Snowgoose Wildlife Trust

Re: THE 'SIR PETER SCOTT CENTENARY CENTRE', Your Ref:H18-0321-11 and H18-0320-11

Further to your email of the 21-6-2011 please find attached a complete and revised copy of our main plans 1/LH/11-rev2, 2/LH/11-rev2 and 3/LH/11-rev1.

Sir Peter Scott Centenary Centre
East Bank Lighthouse, Sutton Bridge
Elevations
Drawing 21lh/11 - REV2
SCALE 1:100
AMENDED PLAN
Ref. A2
22/4/2011

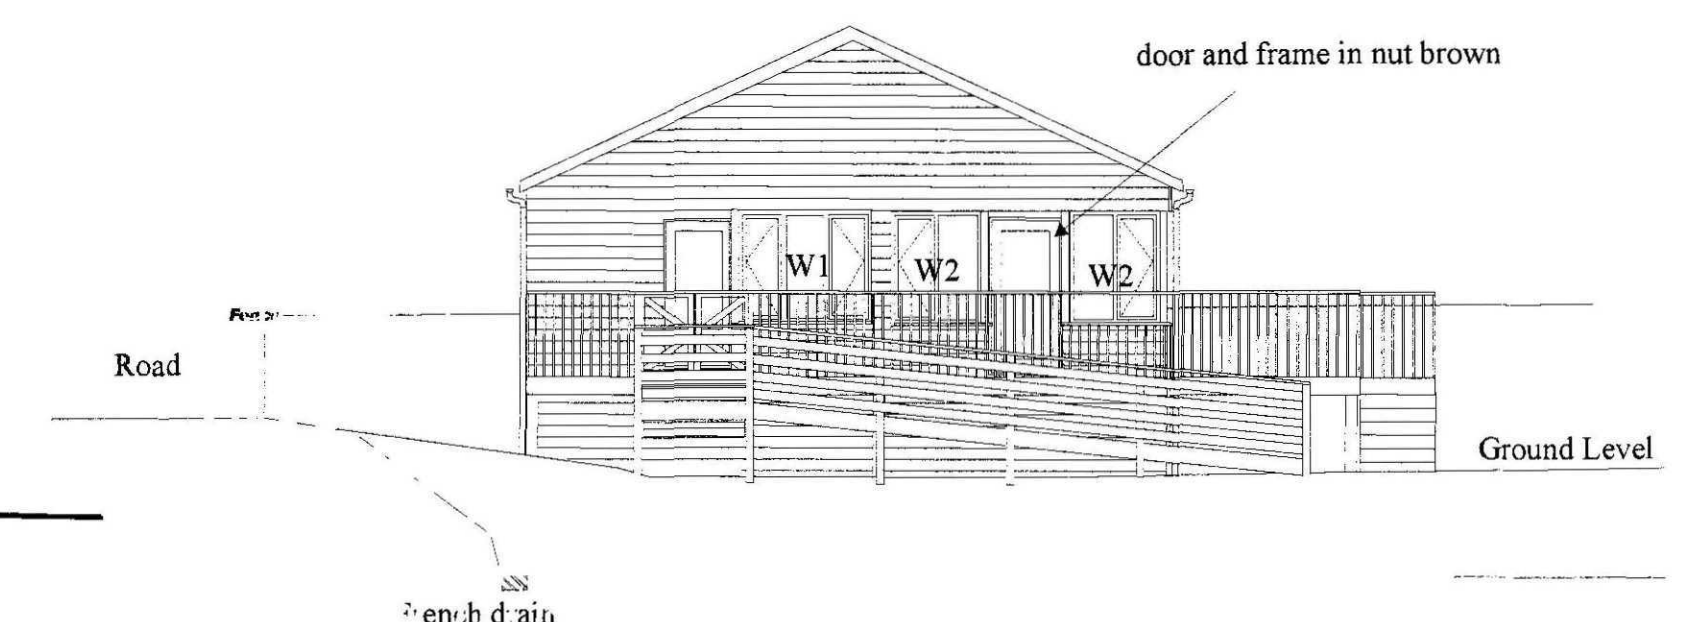
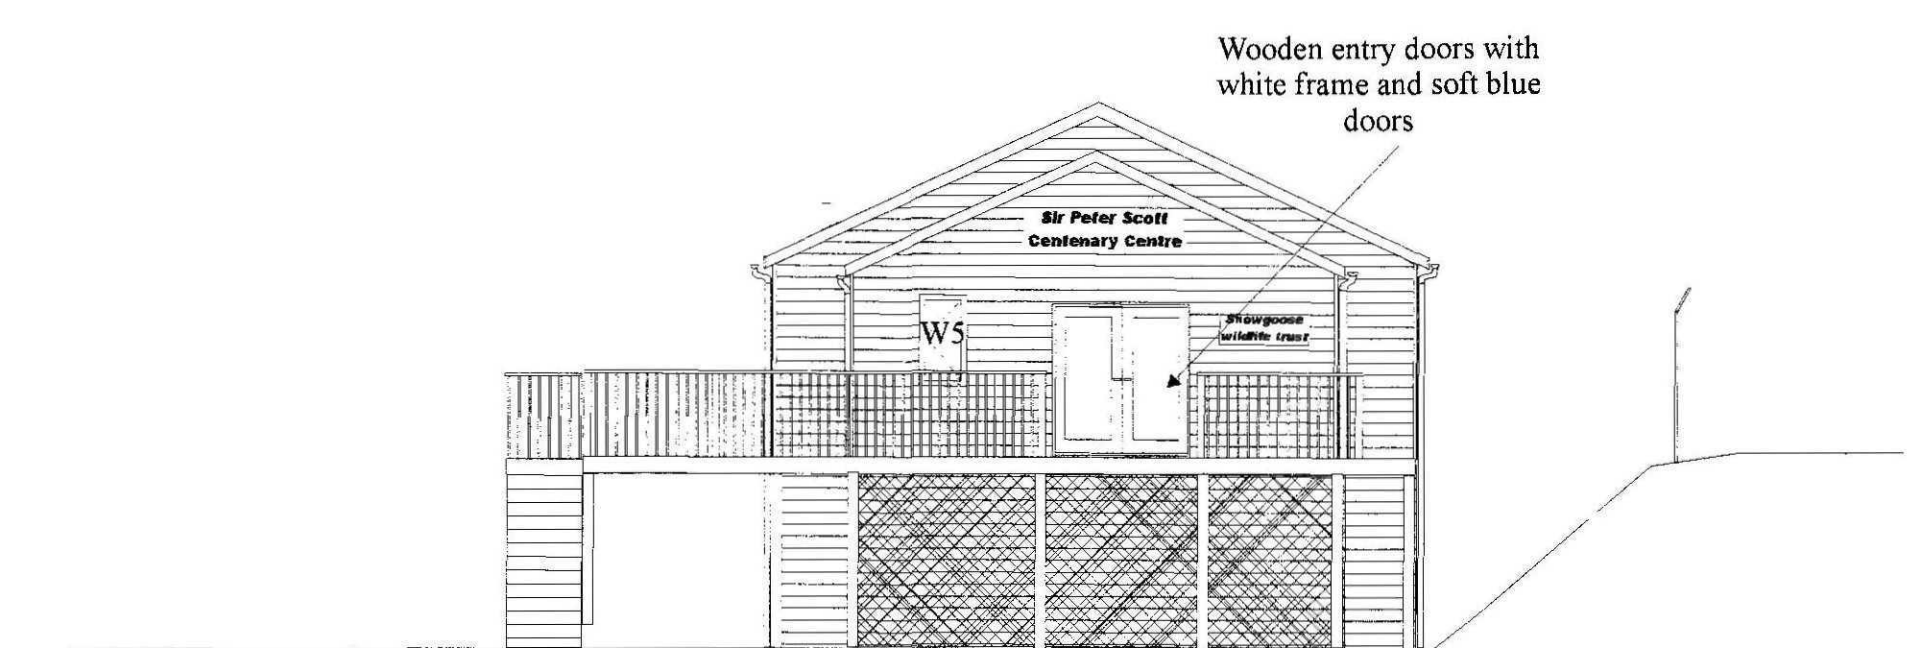
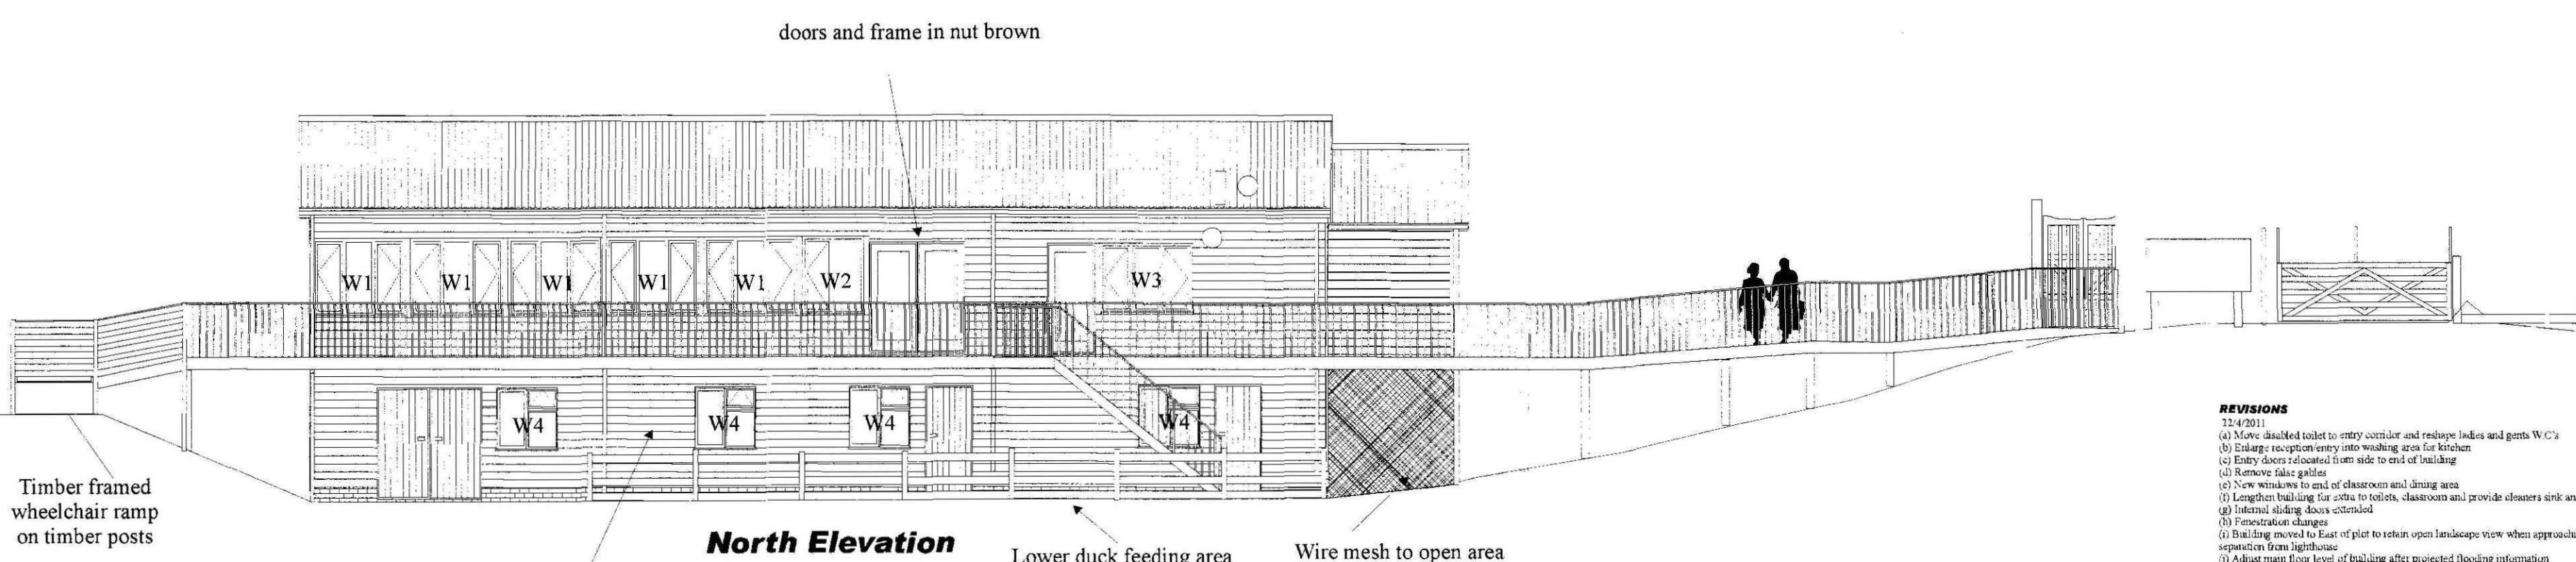
- (a) This is a timber rather than a steel framed building and our structural engineer requires the roof loads to be brought down at maximum 3 metre centres. The windows therefore have 10X10Cm square section timber posts on either side for load carrying purposes but we have tried to make these as regular as possible within the fenestration. The end corner post will be set back by the depth of the exterior cladding and will provide a beneficial open effect both internally and externally.
- (b) Due to the recession, few standard timber window options are presently available, hence a major reason for the original PVC proposals. As mentioned, aluminium and past experiences with small sections have not gone well and thermal performance continues to be a major issue.

We have therefore selected timber conservation flush sashes to achieve that 'simple boathouse look'. We do however require opening windows in this long glazed elevation and without fanlights, 'open out' sashes are a necessity and these are narrower than the windows of your sketch. To prevent them clashing with people passing by, they will need to be fitted with restrictor stays.

- (c) We have tried to balance the doors to the east elevation as shown on the sketch but are fixed with the canteen door due to the internal layout. The window and door types have however altered, as has the position of the classroom door to achieve a much better appearance. Moving the classroom door means the emergency ramp moves with it as it has to be accessible from the straight ahead position on exit for wheelchairs.

- (d) Another window has been added to the lower floor north elevation and all the window designs adapted to suit timber windows. As these are secure stores etc we do need at least one small fanlight each and that dictates the standard style of sashes used.

- (e) Top hung standard casement lights to the south elevation have been changed to timber and the sizes adapted to suit, with an additional light being added to the classroom as the others have reduced in width.

- (f) All external doors have been changed to full glazed timber framed doors. All will be in nut brown stain with the exception of the entry doors that will remain in soft blue with a white frame.

- (g) All external windows will be in nut brown and not white as previously.
- (h) **Listed trees** It is confirmed that the listed sycamore trees numbers one and ten as counted from the highway gate will now be retained.
